Rezoning Transportation Analysis

Petition Number: 2021-127

Date	Description
09-23-2021	First Review (KP)
11-22-2021	Second Review (KP)

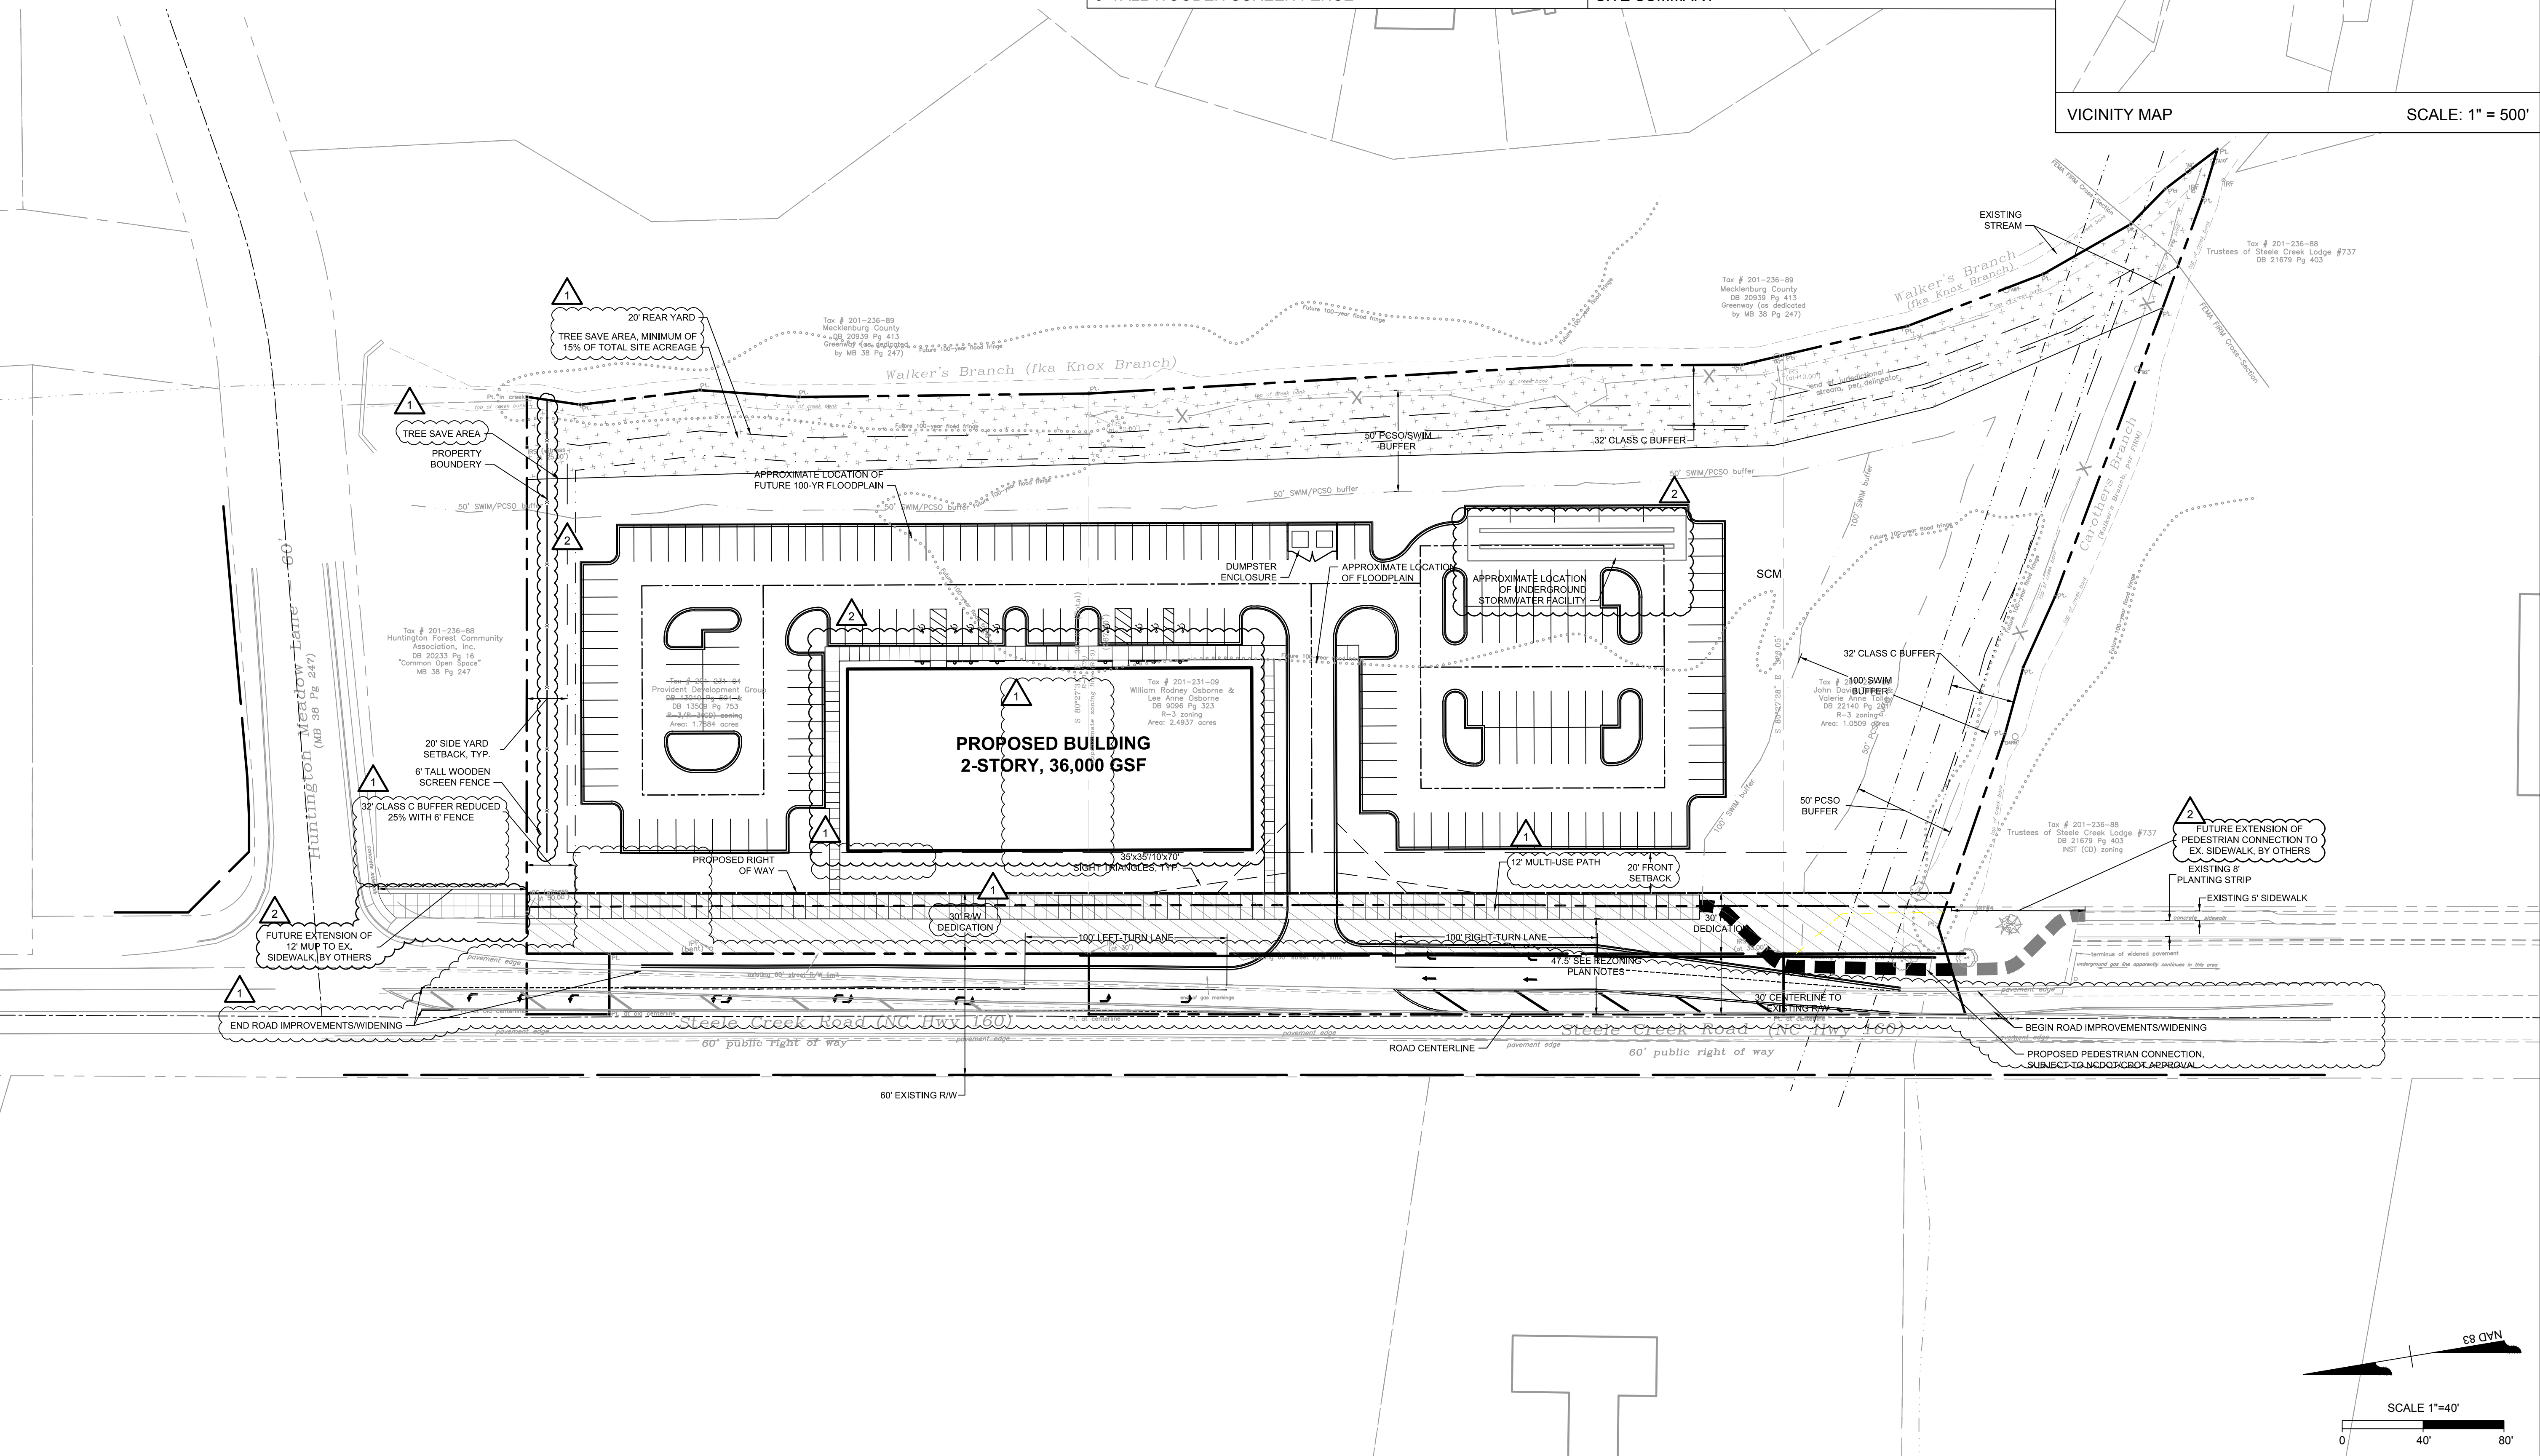
1. **Curb line:** ~~Outstanding Comment from 09-23-2021: U-5766 Curb lane should be labeled and dimensioned from the existing centerline.~~
 - a. **Steele Creek Road:** Curb and gutter is not required with this petition; however, the future location of curb and gutter will be located relative to the typical section associated with U-5766, Steele Creek Road Widening.

Label and dimension the future back-of-curb from the existing road centerline.

13. **New Comment as a Result of the 11-15-2021 Site Plan:** Revise the site plan by clearly labeling the existing and proposed striping, on Steele Creek Road, by the approved Parkside Crossing Development (SDRMU-2021-00003).
